Application No: BR/42/22/PL
Site Address: Prince Of Wales Public House 1 Highfield Road Bognor Regis PO22 8BQ
Description of works: Change of use from public house (Sui Generis) to an 18-bed student accommodation. This application is in CIL Zone 4 (Zero Rated) as other development.

Thank you for your internet representation made on 6th April 2022 which has been recorded as no objection with the comments as follows:

Drawing Title:
PROPOSED FLOOR PLANS, ELEVATIONS, SECTION

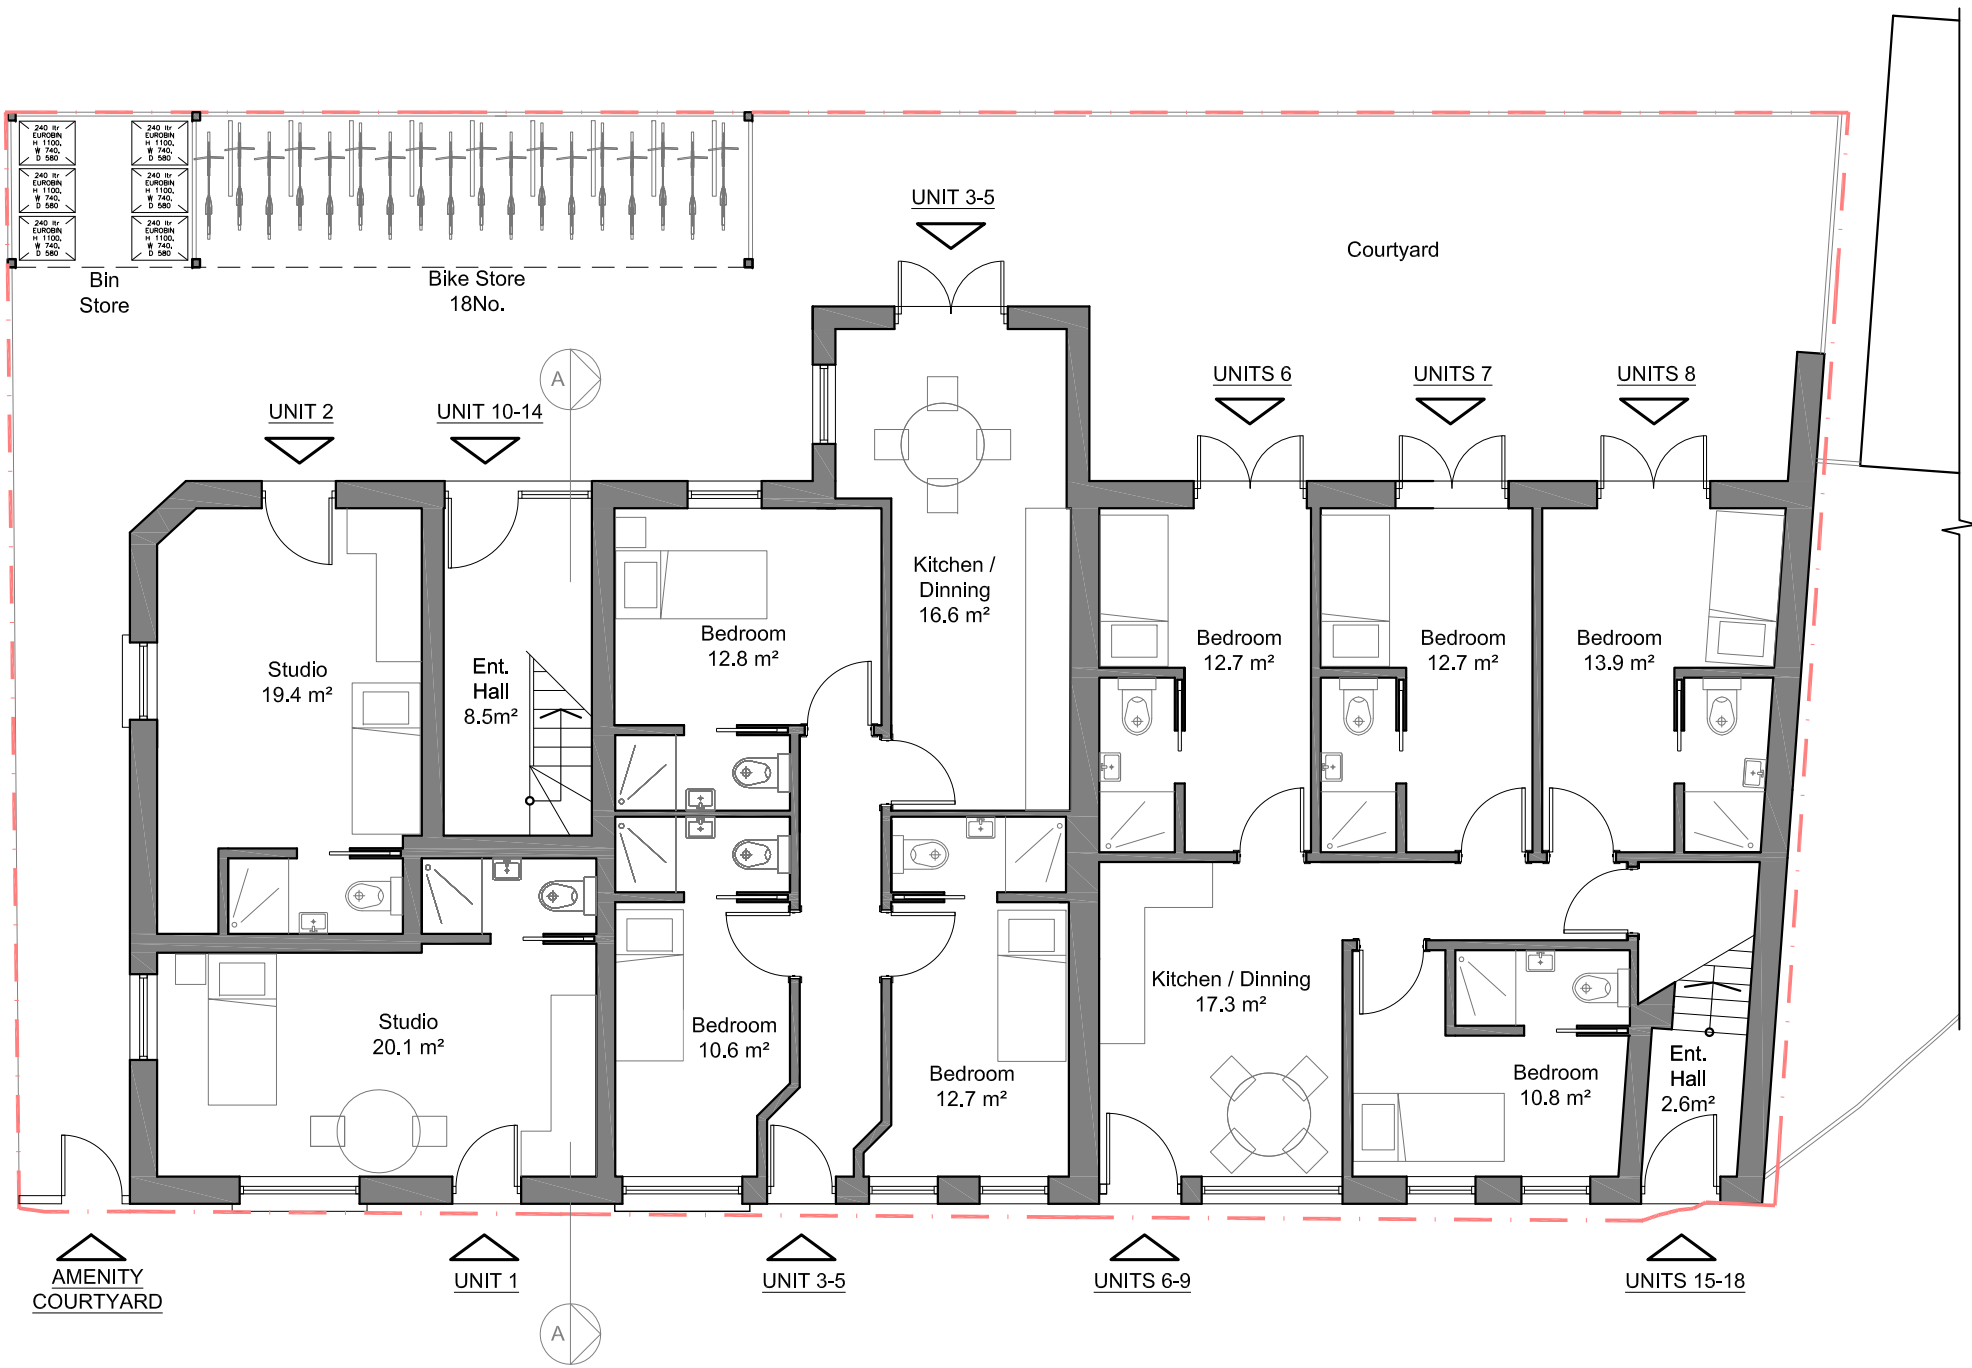
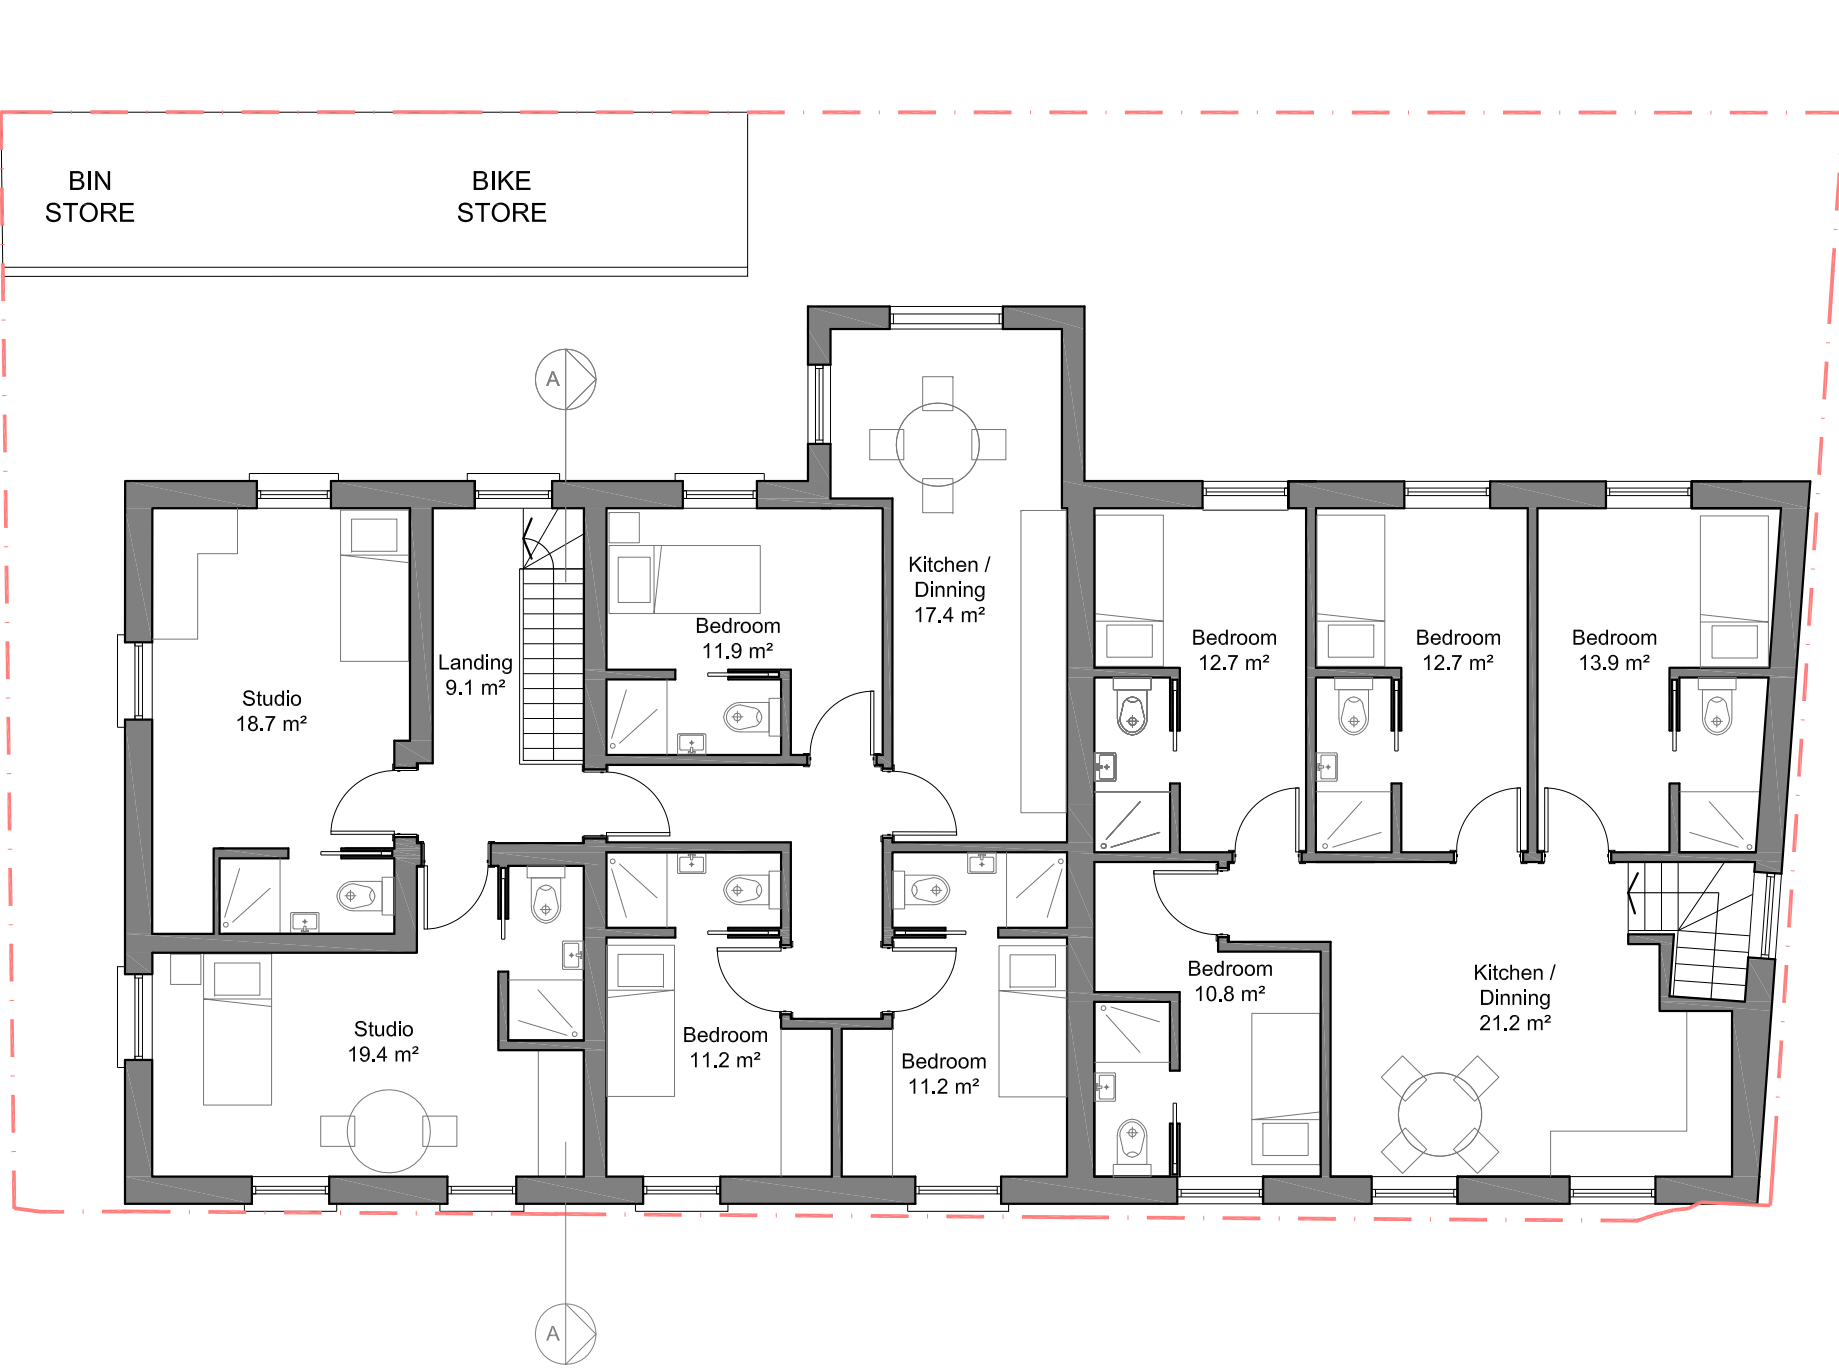
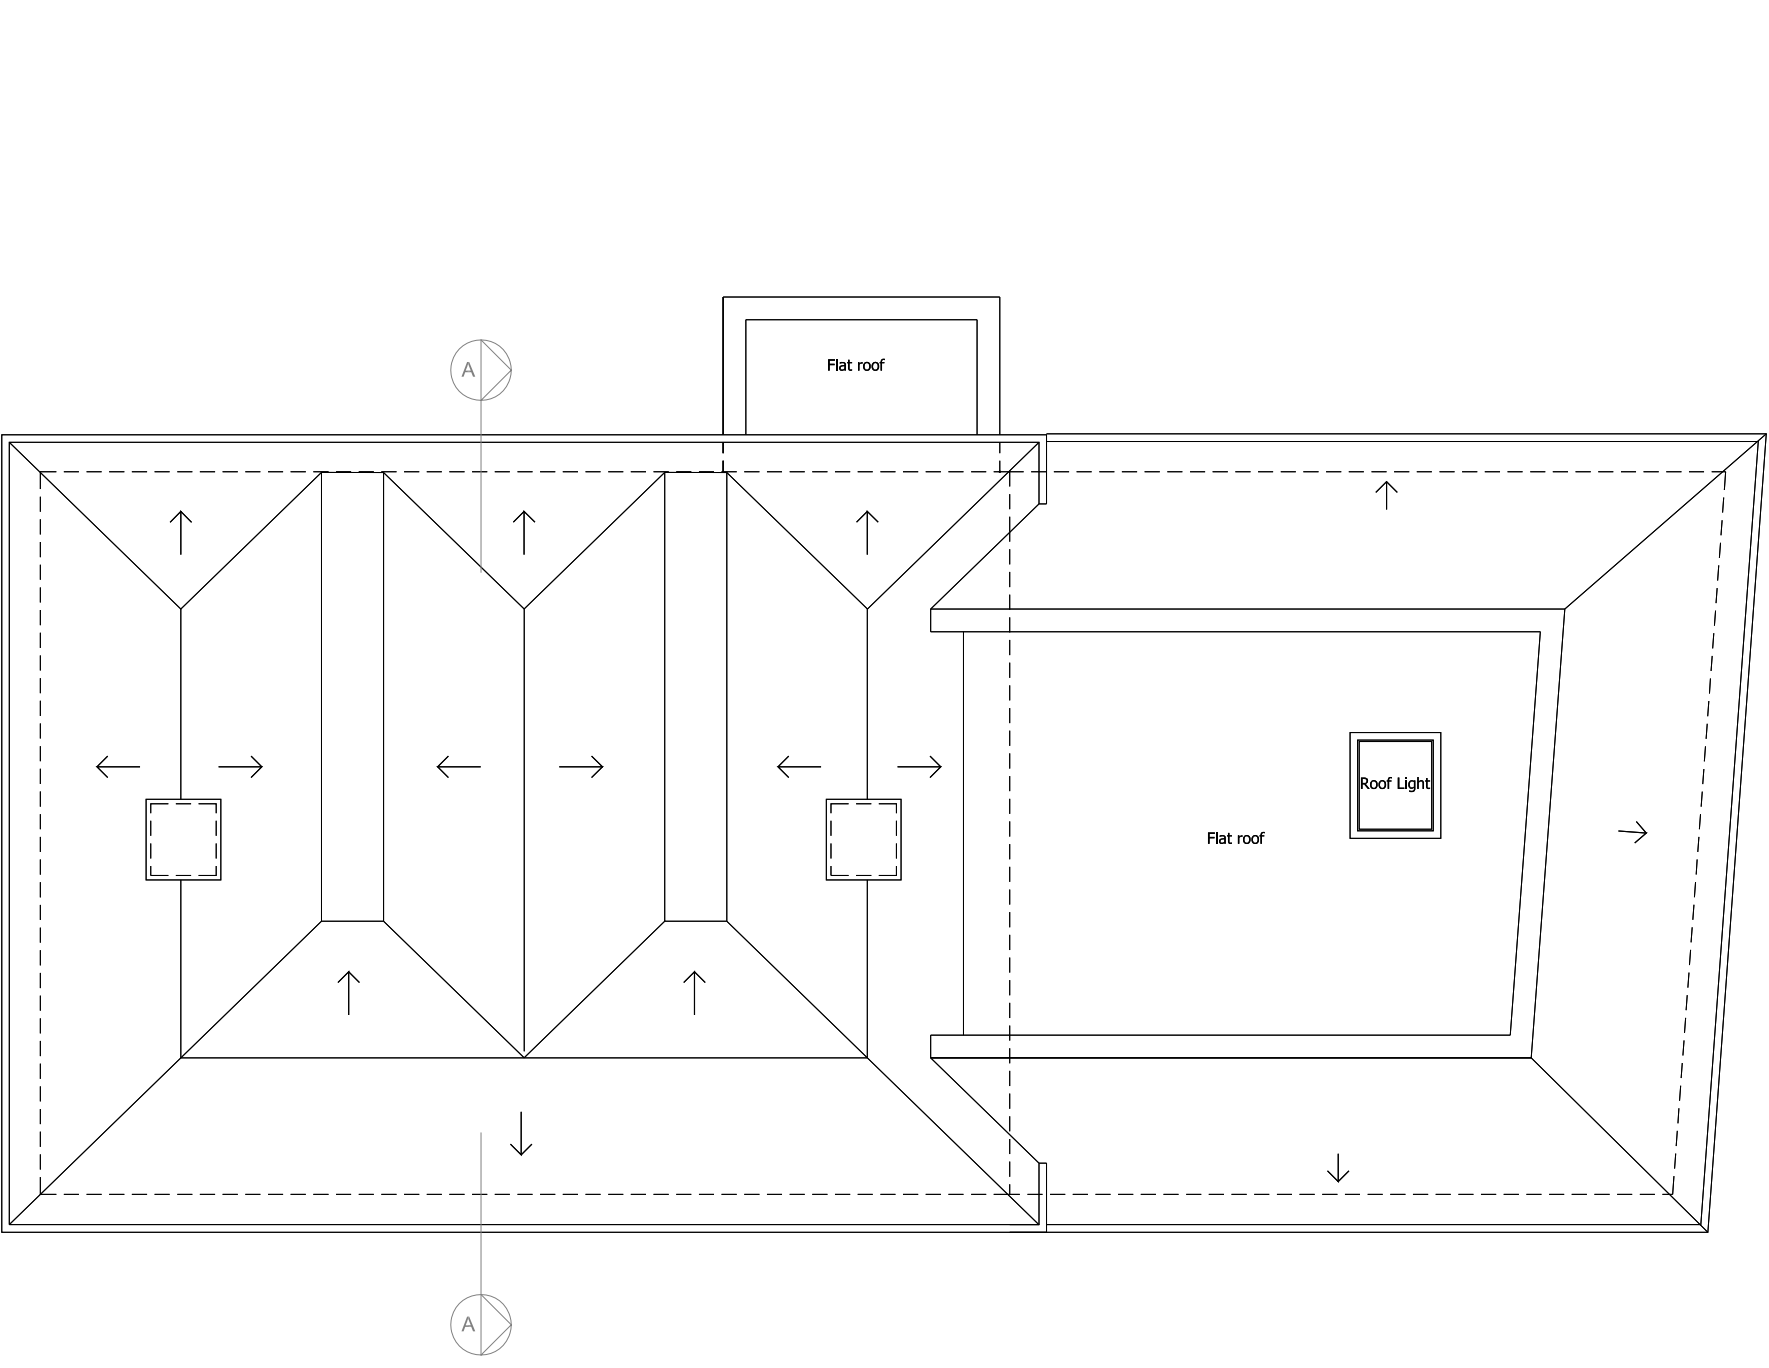
NO OBJECTION Provided that a student tenancy agreement prohibits car ownership, as with other planning applications for student accommodation in the Town such as BR/38/22/PL, then Members are minded to raise no objection to Planning Application BR/42/22/PL. It would be preferable if the two car parking spaces indicated in the proposals were reserved for use by staff.
